Addendum No. 1

RE: Contract # C204902
WBS # 15BPR.102.3
STATE FUNDED
New Hanover County
CAPE FEAR MEMORIAL BRIDGE.

November 21, 2023 Letting

PROJ. REFERENCE NO.	SHEET NO.
15BPR.102.3	TMP-7

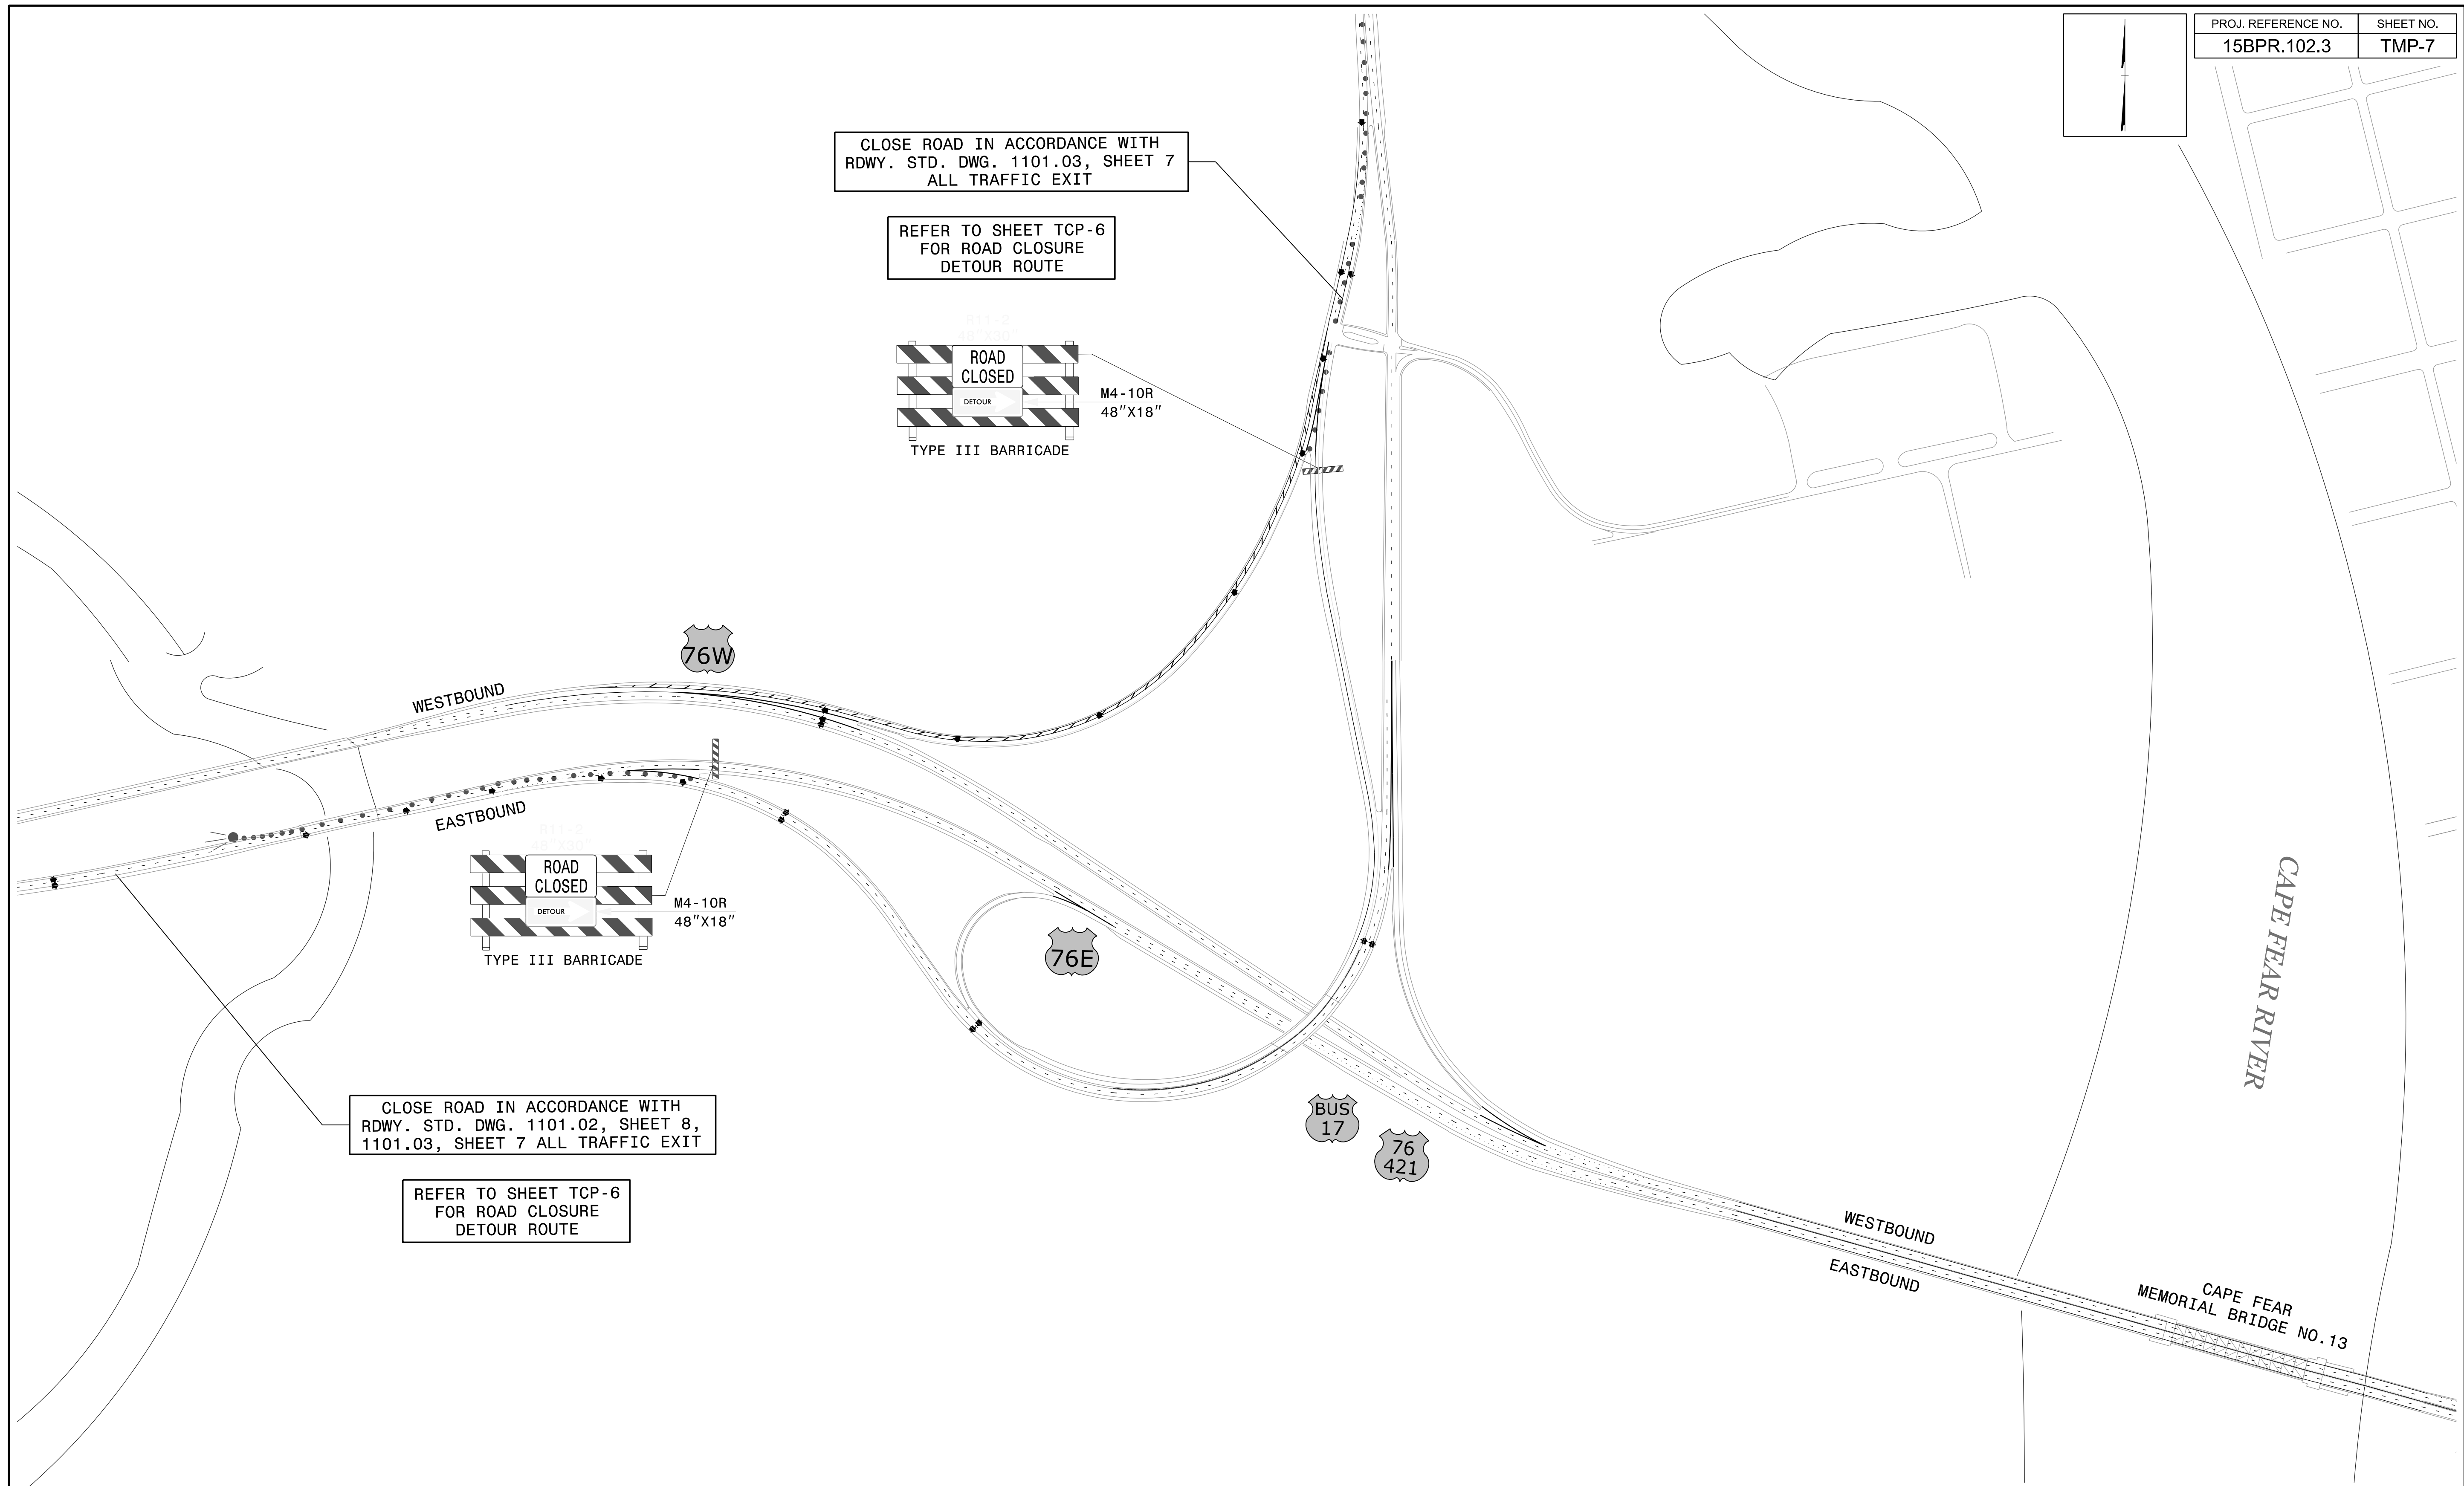
Sheet No.	Revision
TMP-1, TMP-3, TMP-6 thru TMP-10	TMP plans revised to close the Eastbound side of the bridge first.

NO.	BY:	DATE:	NO.	BY:	DATE:	SHEET NO.
1			3			S-5
2			4			TOTAL SHEETS 21

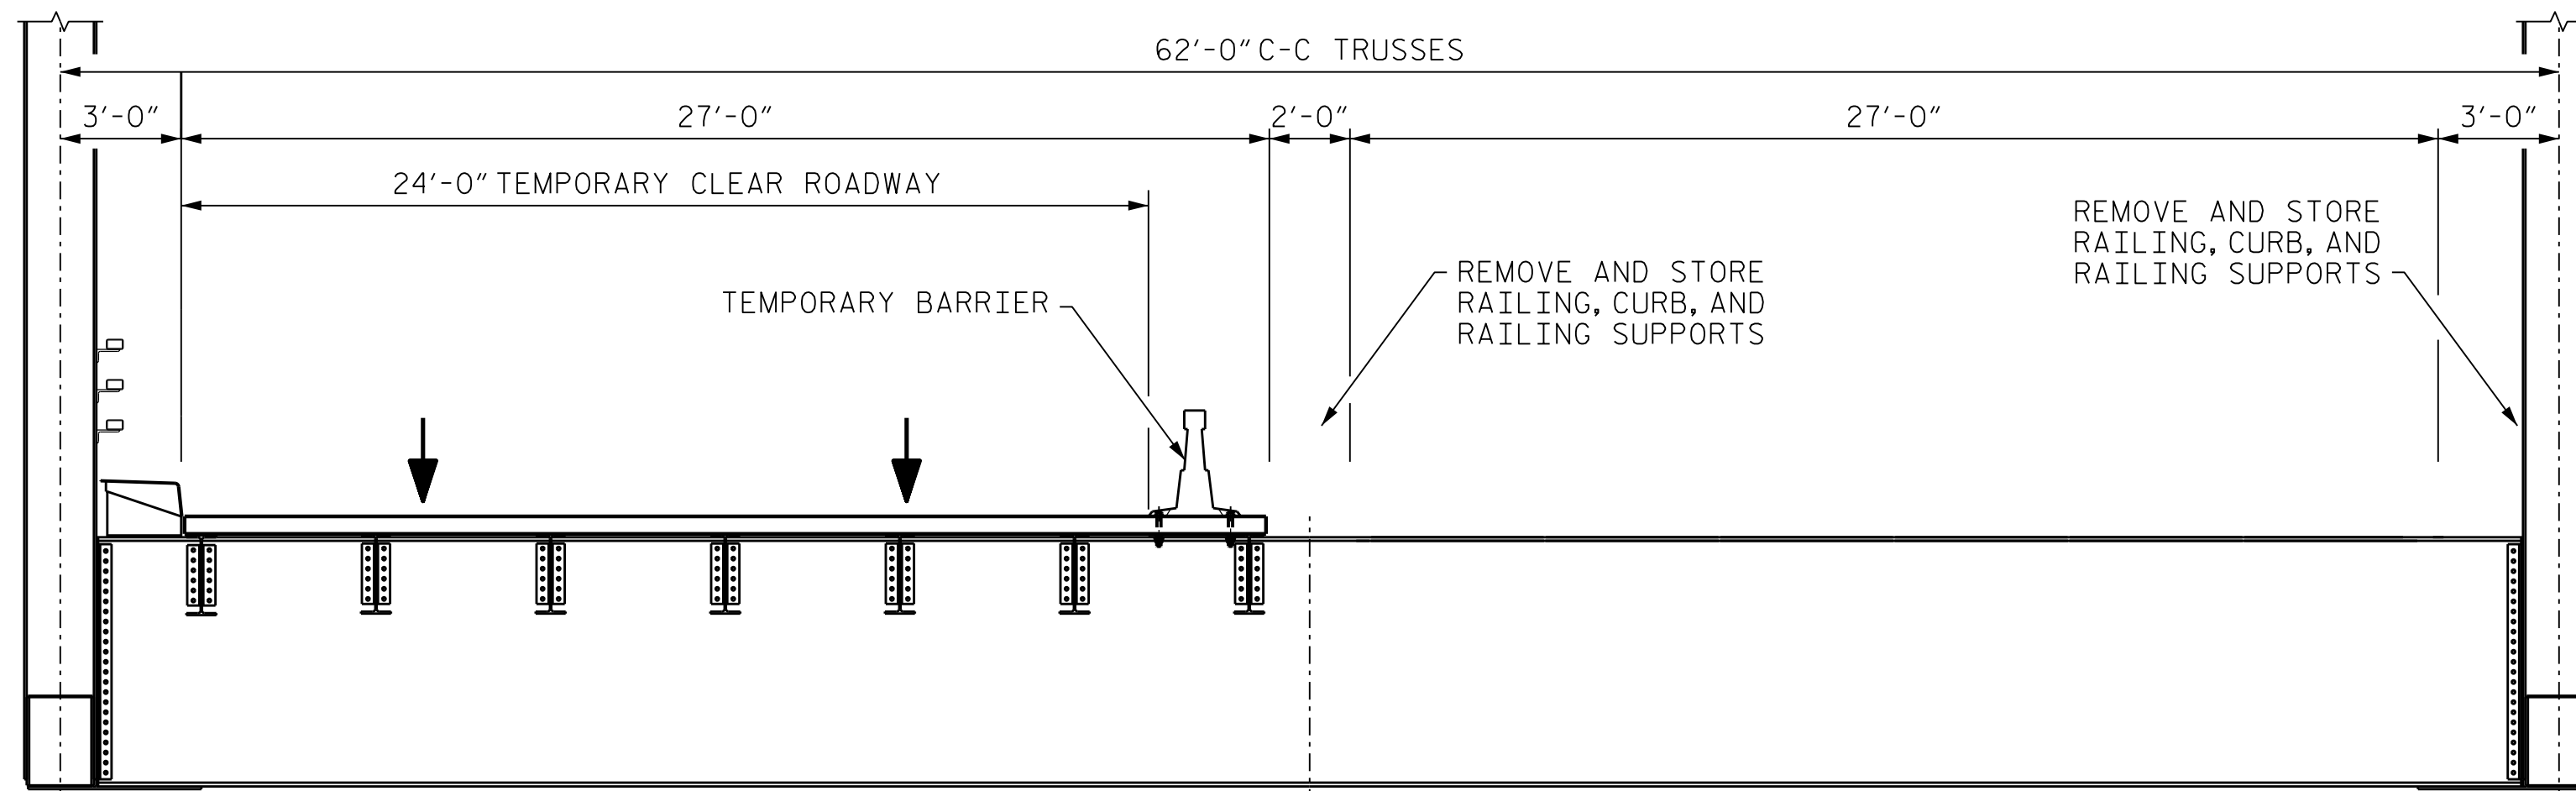
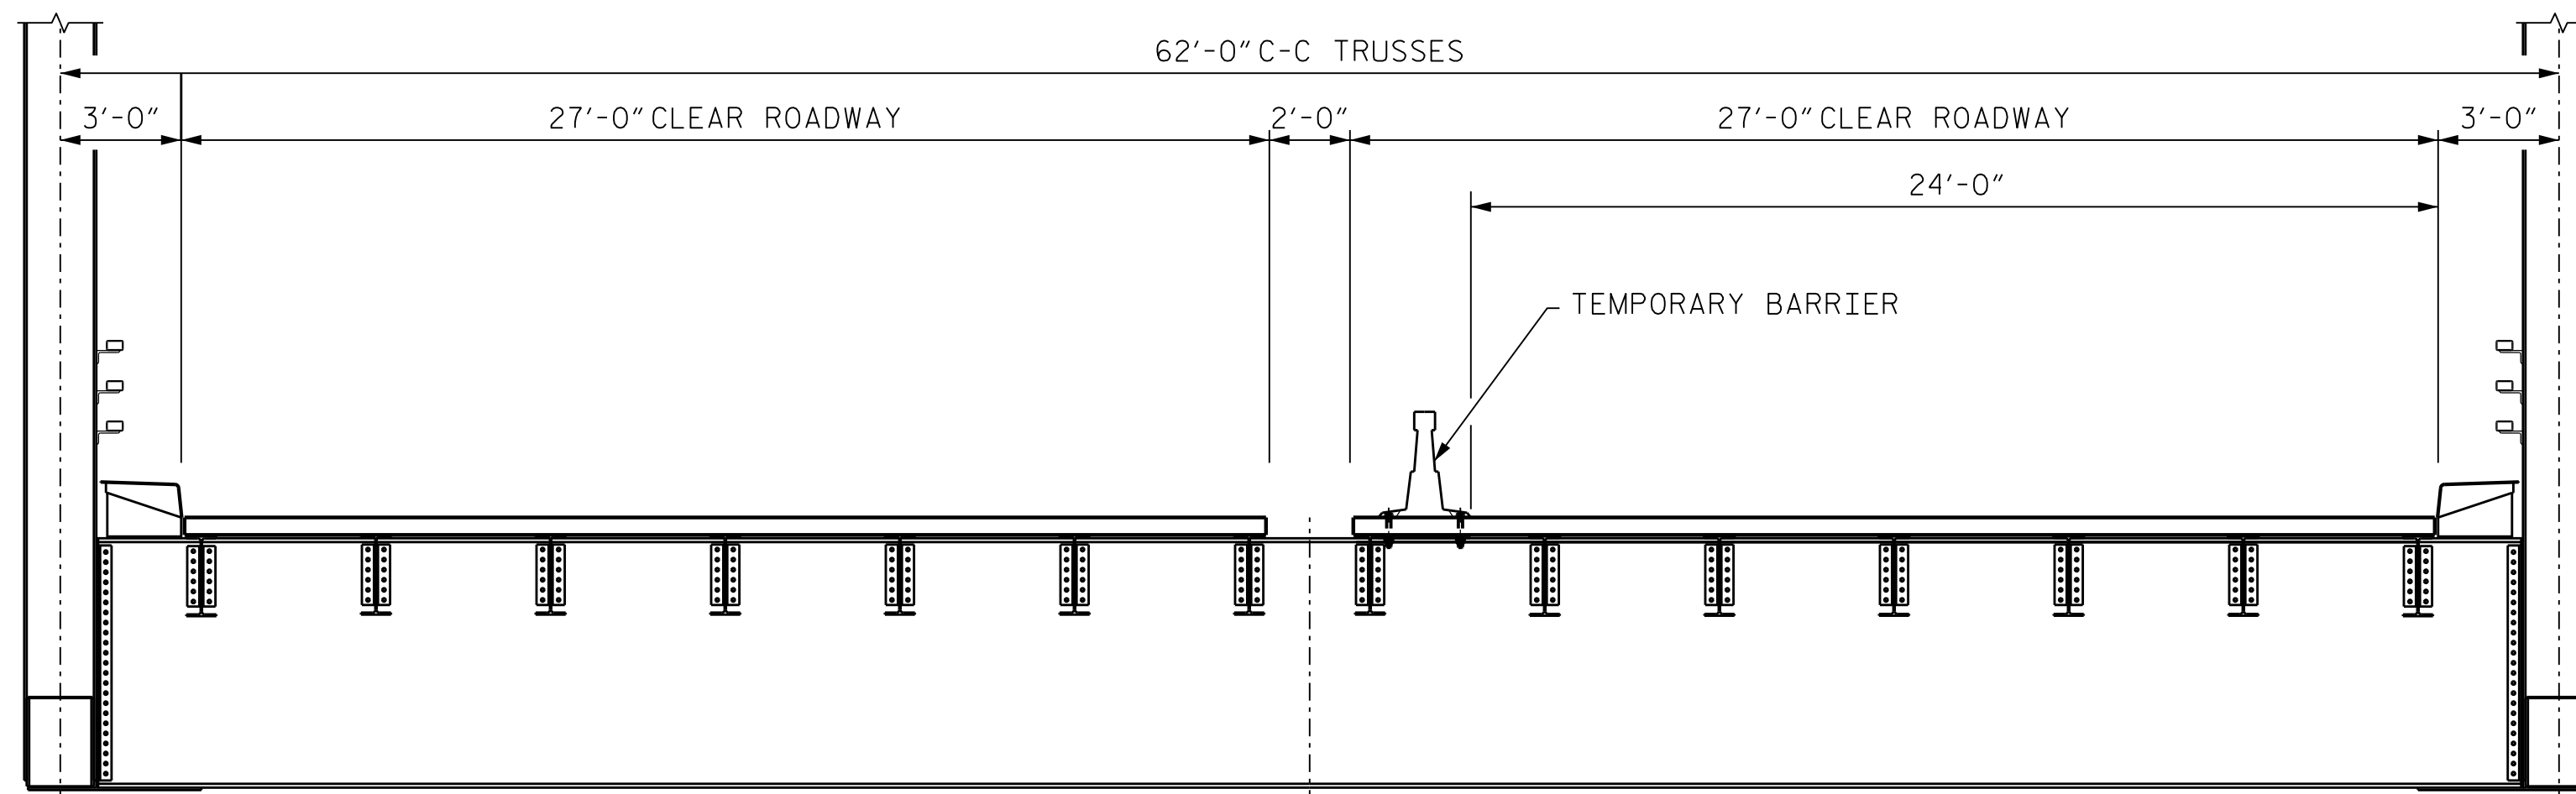
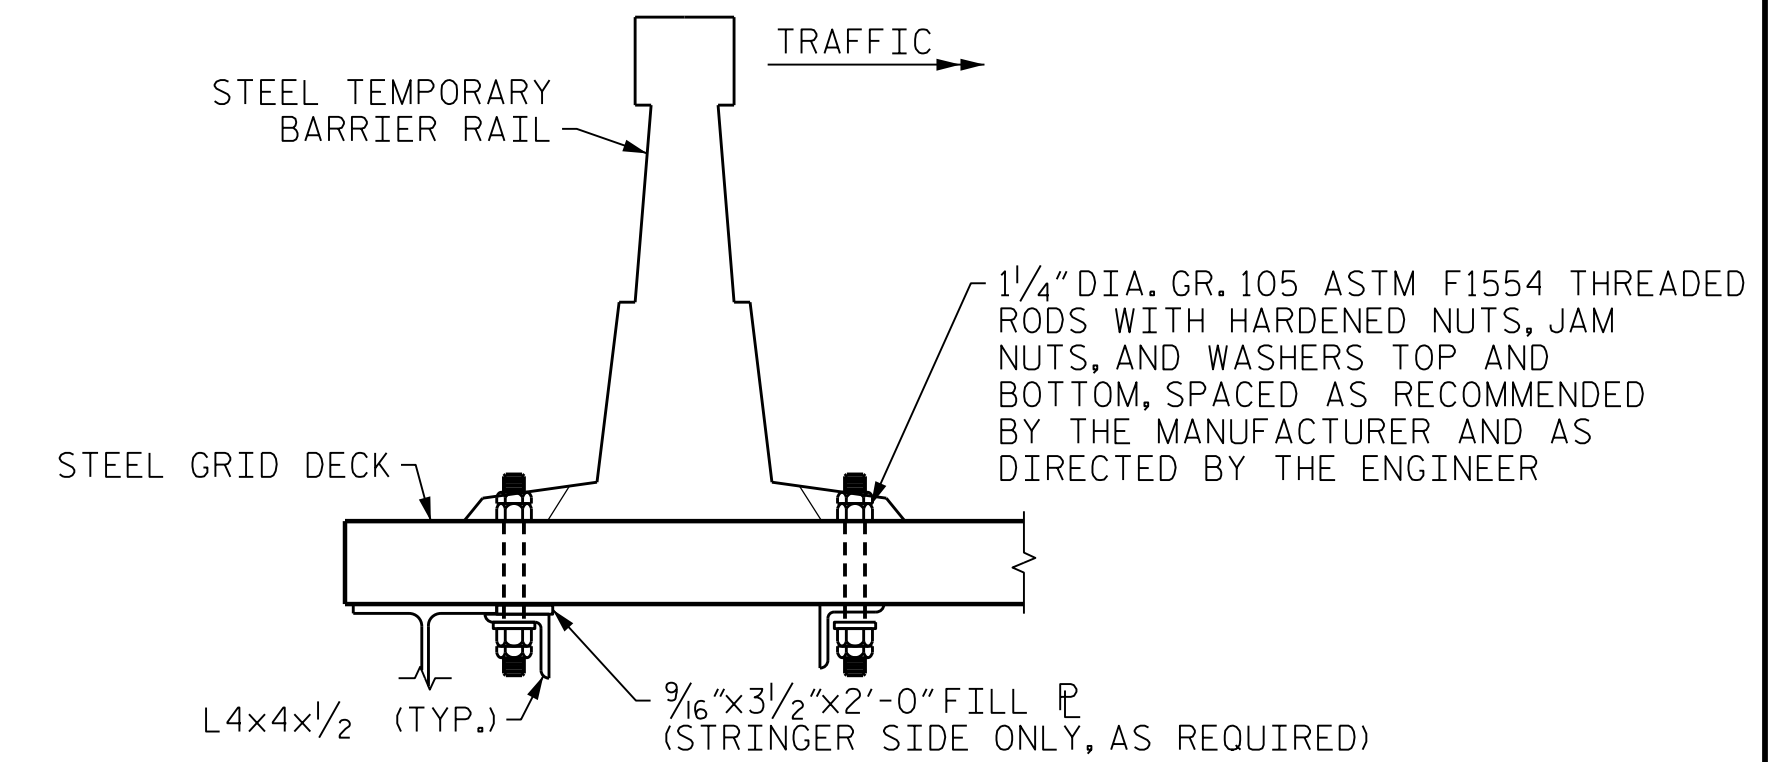
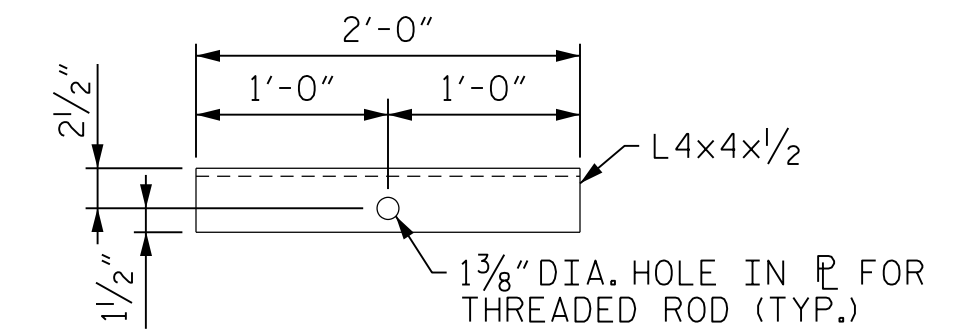
Sheet No.	Revision
S-5, S-6, S-15, S-17	Revised to indicate that the eastbound side of the bridge grid deck and structural steel is to be done first and to indicate that temporary bracing must be installed to facilitate opening the bridge while Stringers S2, S13, S7, and S8 are removed.
